Subject: Pottinger Wind Farm – Response to Further Requests for Additional Information – TfNSW and BCS

We refer to the Department of Planning, Housing and Infrastructure's (DPHI) request for additional information regarding the Pottinger Wind Farm (SSD-59235464), in response to further RFIs from:

DRAWN: OM
DATE: 28/11/2024
DWG NO: 768 F03E - WF
SCALE at A3: 1:1000

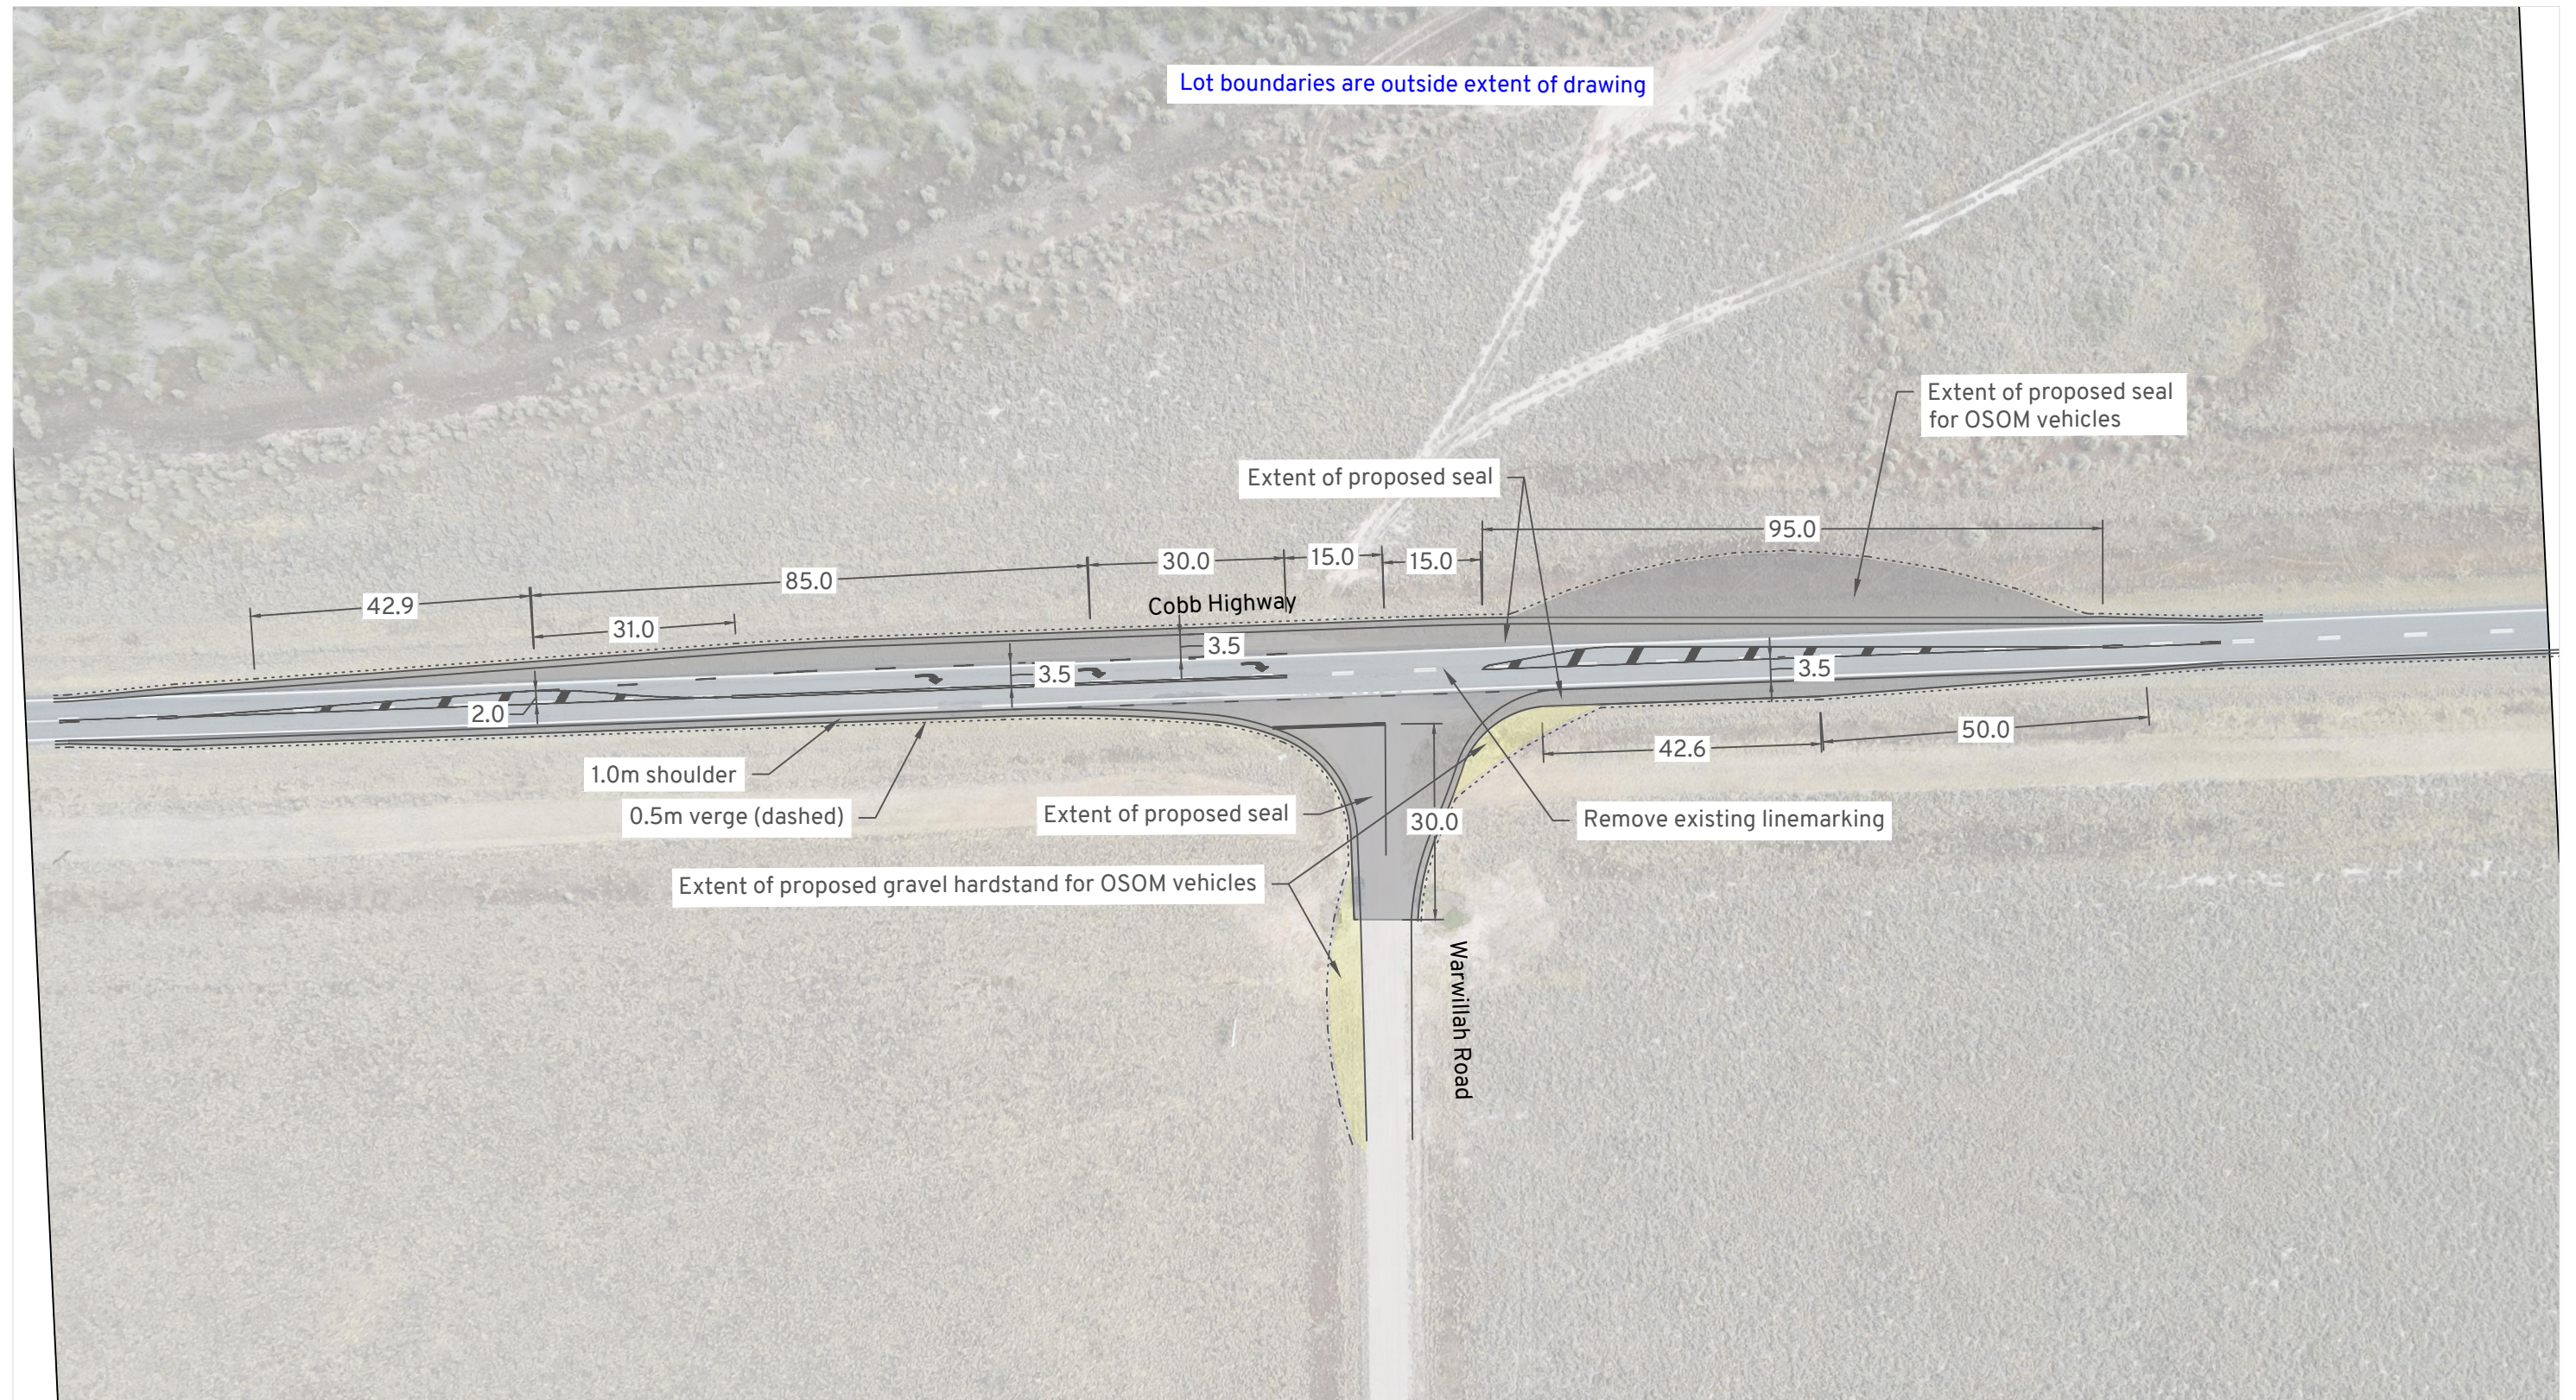
| Date | TfNSW request | Date | Response | Date | TfNSW Further Request | Date | Response |
|------------|---|------------|---|------------|---|----------|--|
| 16/01/2025 | Provide revised swept path diagrams with the wheel tracks shown. These are needed for key intersections identified for upgrades, as well as the intersections within Broken Hill (on Silver City Highway near Crystal and Chloride Street). | 17/1/2025 | Provided vehicle swept paths with wheel and load tracking on Silver City Highway near Crystal and Chloride Street. <u>Please see Appendix A for final document.</u> | 30/01/2025 | Regarding Appendix B • Page 8 – Chettle St/ Barrier Highway – no swept paths have been provided to show entry onto the Barrier Hwy. Swept paths for this needs to be provided for assessment. • Page 10 – 11 (option 1) – Cobb Hwy/ Sturt Hwy - Need to show the swept paths and how it is intended to navigate the raised islands on approach in order to travel in the northbound lane. - The swept path appears to show the OSOM vehicle running off the road on entry into the roundabout. Any widening to accommodate this needs to be identified on the design. - At the arrow “mountable kerb profile with concrete apron, reinstate if damaged”. It appears that the concrete apron would not be wide enough to support the OSOM movement. The concrete apron would need widening to support the wheel path. Please outline this on the design. - Design shows there is impact to lighting and power infrastructure. | 5/2/2025 | Provided swept path showing entry onto Barrier Hwy. <u>Please see page 8-9 in Appendix B for update.</u> Additional changes: -Swept paths showing how vehicle navigates the raised islands on approach to travel in the northbound lane. -Confirmed OSOM vehicle will stay on road on entry into roundabout. -Confirmed OSOM vehicle wheel path is expected to use mountable kerb profile with concrete apron and project would reinstate if damaged. -Used updated aerial imagery for Pinch Point 11 options 1 and 2 to give certainty to updated comments. -as per updated imagery, roundabout has already been upgraded with a mountable annulus. <u>See Appendix B for final document.</u> |

| Date | TfNSW request | Date | Response | Date | TfNSW Further Request | Date | Response |
|------------|---|------------|---|------------|---|----------|--|
| | | 23/01/2025 | Provided revised swept path diagrams with the wheel tracks shown for key intersections identified for upgrades. <u>Please see Appendix B and C for final document.</u> | | | | |
